ADC PARKS & GREENSPACE ARBORICULTURE CONSULTATION

PLANNING APPLICATION: **A/34/13/T**

ADDRESS: Verge at front of 2, 12, 28, 32, 34 and 36 East Drive Angmering
BN16 4JN

BRIEF DESCRIPTION: Fell 2 No Monterey Pine trees, crown lift to 2 m 1 No Monterey Pine tree, reduce to West by 2-3 m and reduce to North by 3 m to 1 No Monterey Pine tree, crown lift to 3 m to 1 No Monterey Pine tree, and remove deadwood from 1 No Monterey Pine tree

East Drive, Angmering, West Sussex
Appendix 5

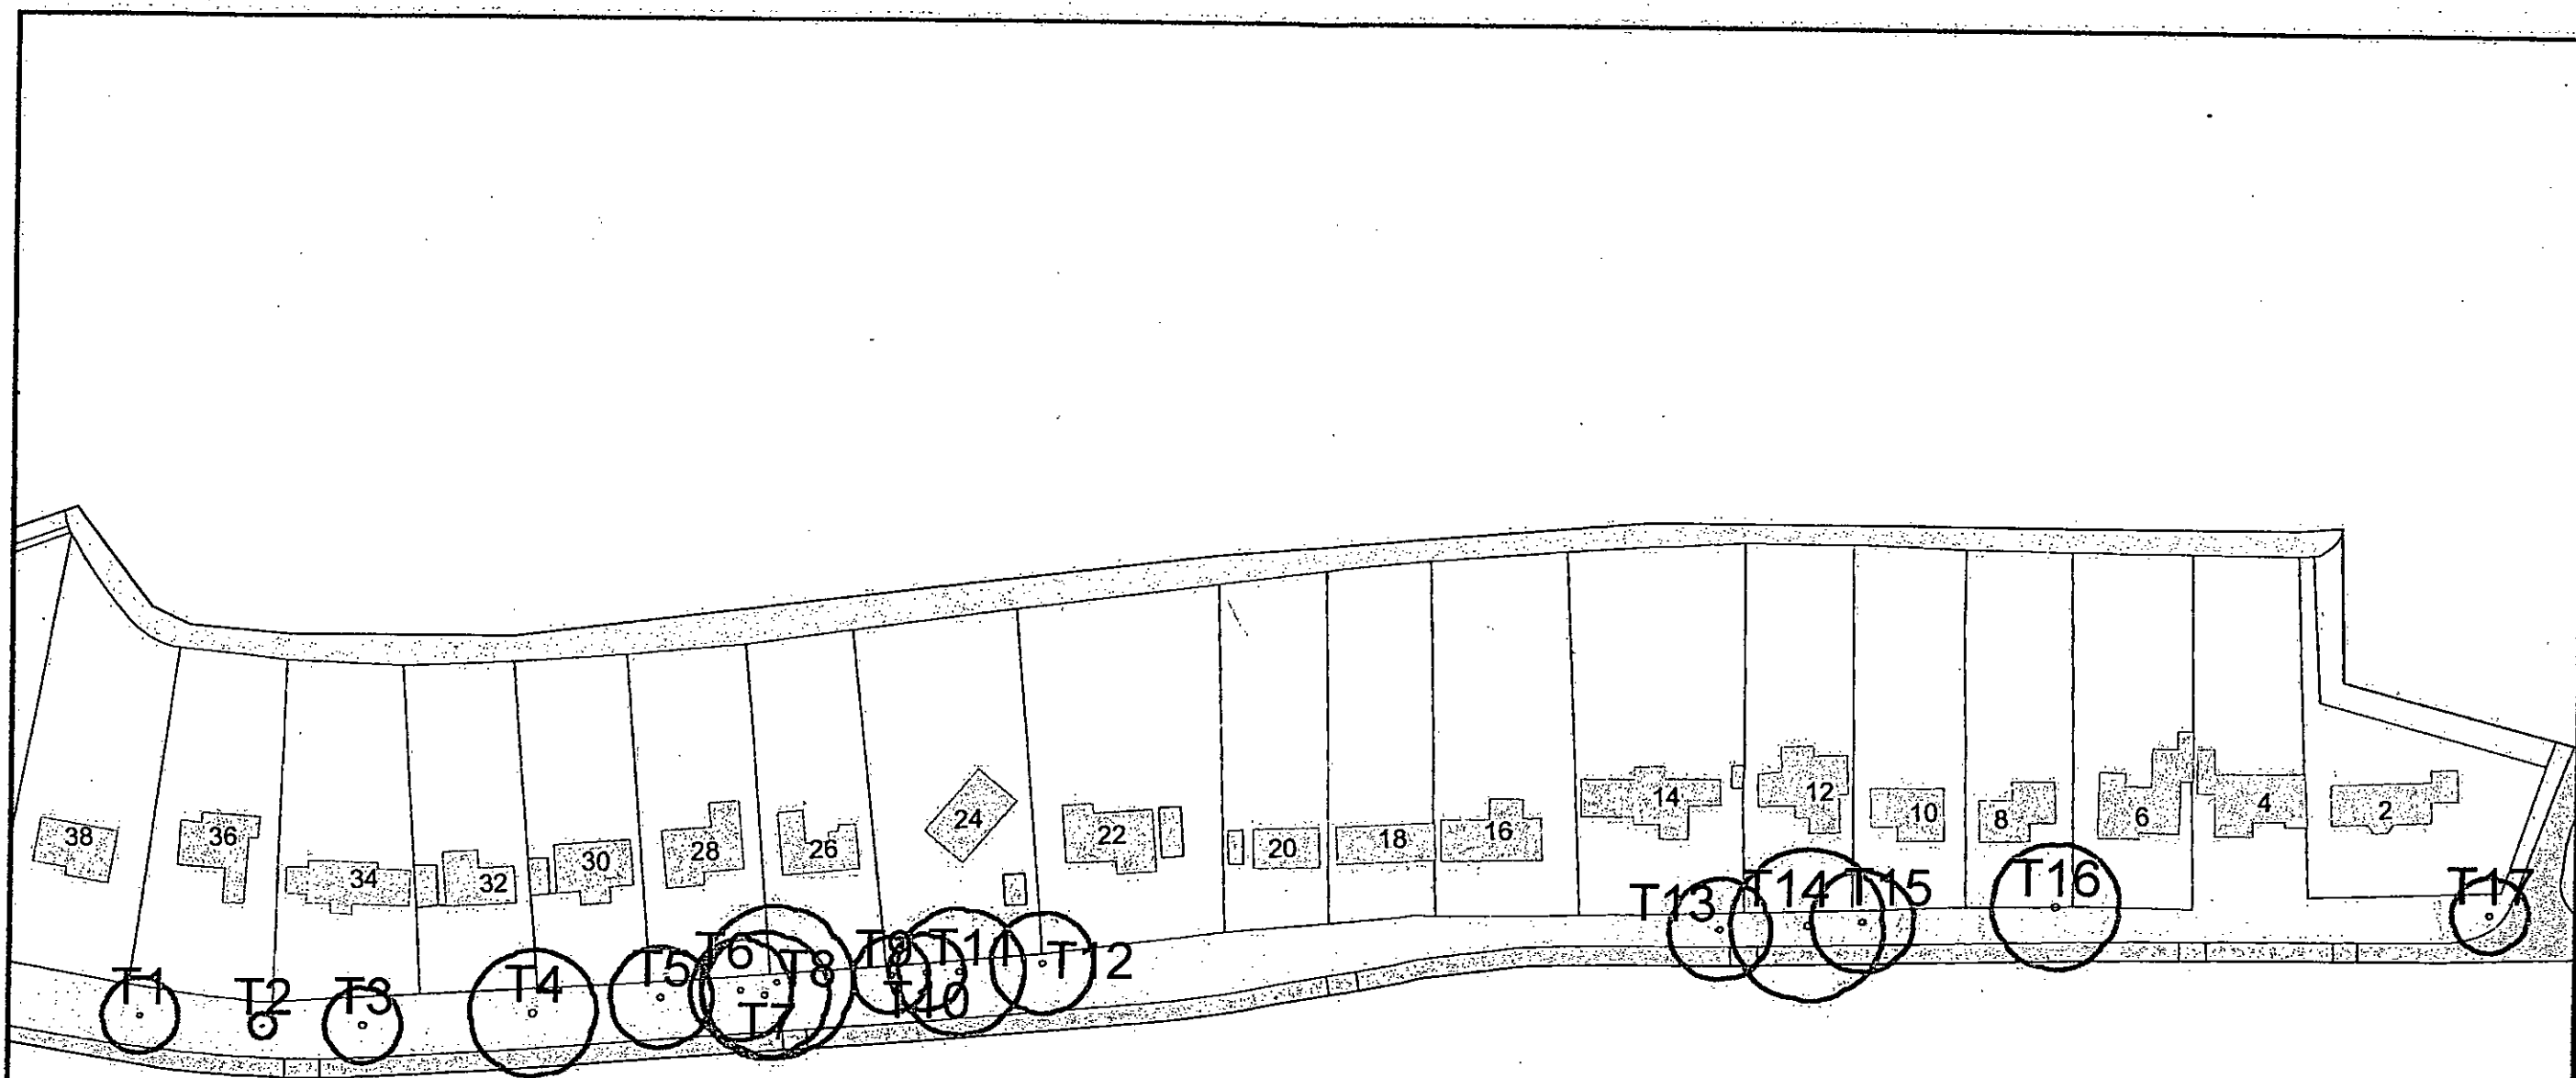
I have inspected the two trees proposed for removal and the one for a crown-lift of lower branches and confirm the findings of the arboricultural consultant and need for the work.

It is recommended that both trees are replaced in accordance with the tree replacement requirements as part of the Town and Country Planning Act as a condition to be planted within 12 months with similar species Monterey Pine (*Pinus radiata*) or considered a variant with Austrian Pine (*Pinus nigra* var. *nigra (austriaca)*).
